Subject: Re: FW: Townend Farm.objections to retrospective application.

Objection submitted on 20th August 2025.

The clients retrospective application for an agricultural building with additional external works includes a technical review as an element of the information submitted.

Drawing title
As-Built Site Plan and
Retaining Wall Elevations

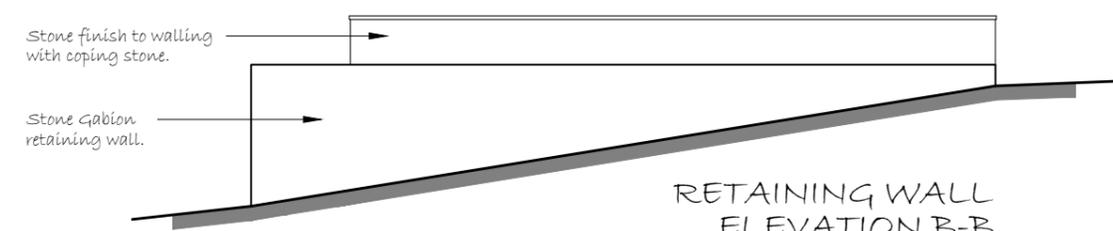
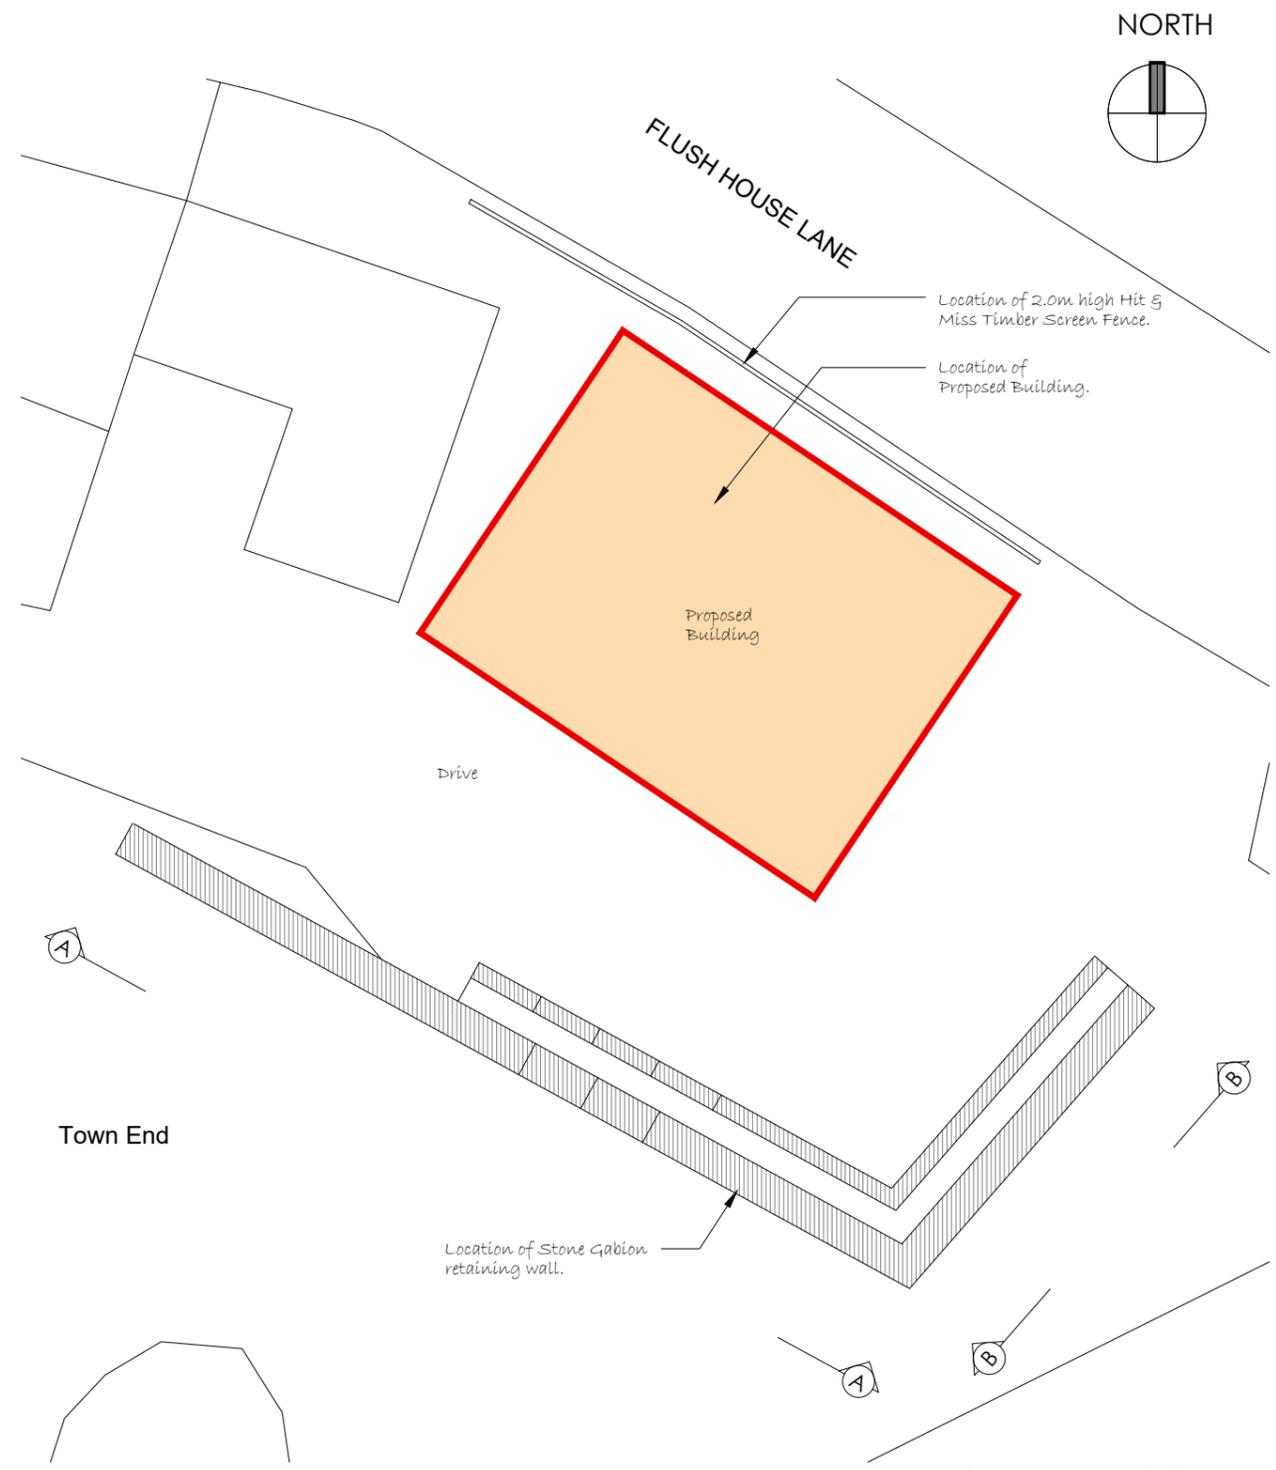
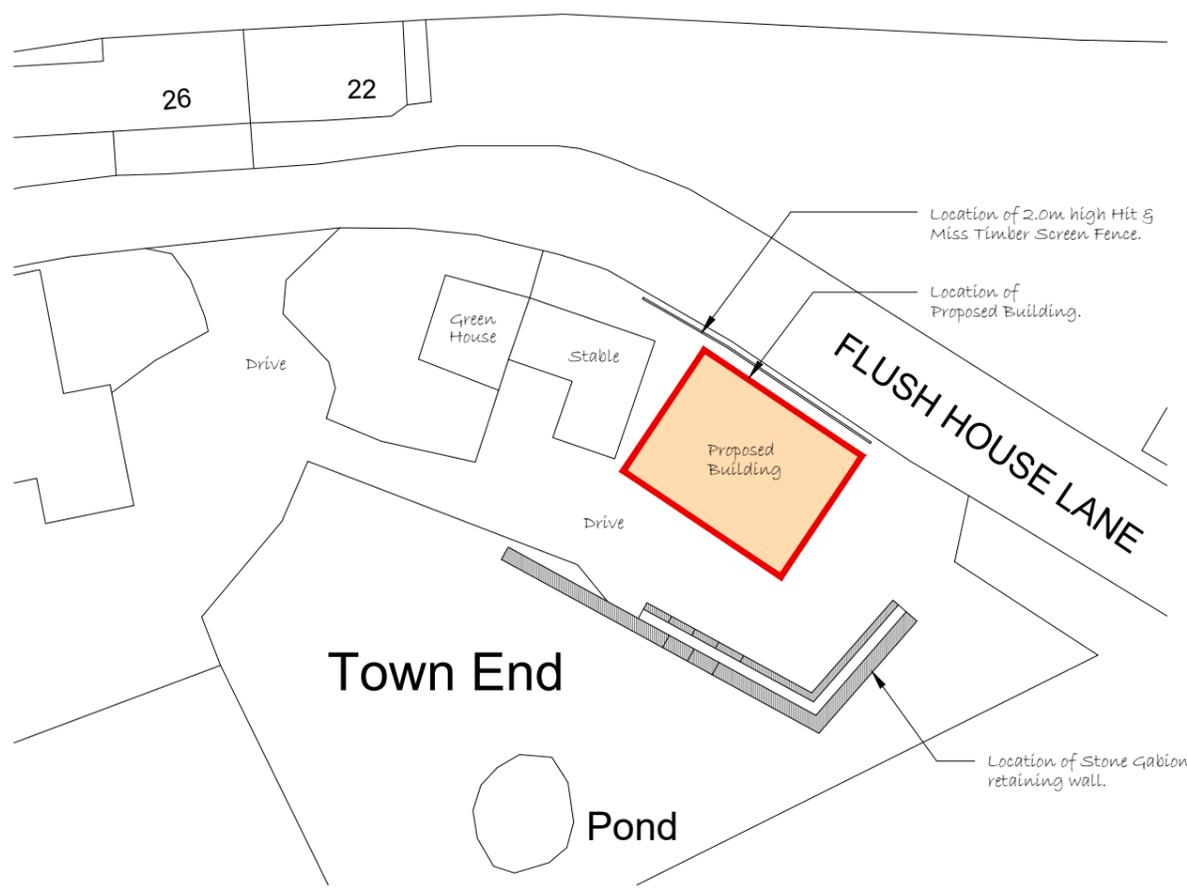
The plateau of 3m in width considerably underestimates the size / dimensions of the hardstanding now established as permanent as opposed to anything enabling for the works duration.

This property, domestic dwelling construction, has purposefully created a much larger hardstanding with a surrounding 'garden type, stepped and flat topped stone wall. Not typical for an agricultural building but typical for a non agricultural building. In creating the much larger construction and plateau area, along with ground source heating works the land gradient has been completely altered by the client. The gabion wall now constructed to 'hold' the plateau is neither typical or aesthetically in keeping with anything else in the locality. Its size, it's scope, the only reference to its situ is the use of stone as opposed to pebble infill.

No attempt has been made by the client to modify the scale of this wall leaving it exposed as it would be on a setting other than anything rural or agricultural.
